Please ask for: Nicola Moore
Email: nicola.moore@arun.gov.uk
Telephone: Ext 37944
Our Ref: LU/114/21/CLP
Your Ref:
Date: 15th April 2021

Lawful Development Certificate for a Proposed Use or Development

Development: Lawful development certificate for a proposed new timber dormer to replace existing brick dormer to rear of property on first floor.
Location: Apple Tree Cottage Toddington Lane Littlehampton BN17 6JX

Proposed Roof Plan.

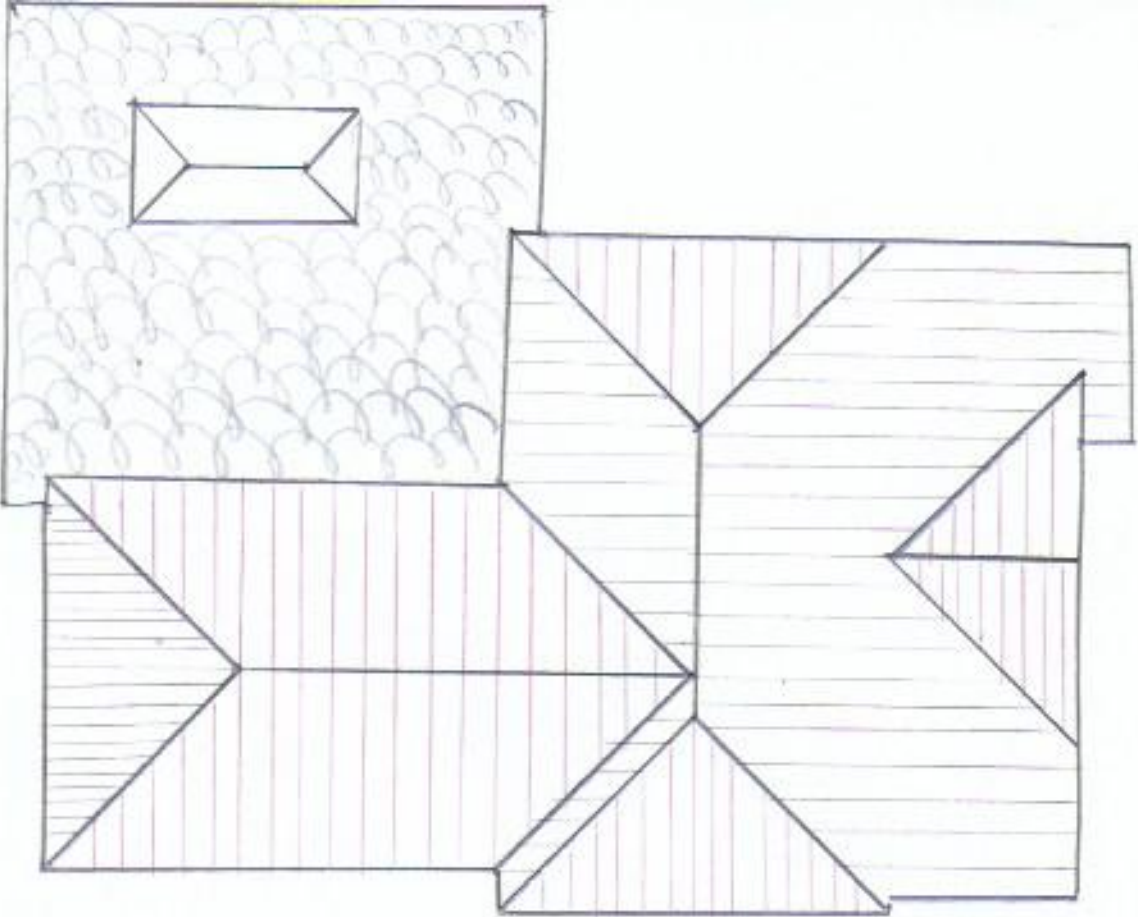
On checking the measurements on the submitted plans, the dormer measures 7.6m on the proposed floor plan and 7.3m on the proposed roof plan and proposed north elevation. Please check the measurements amend accordingly and re submit.
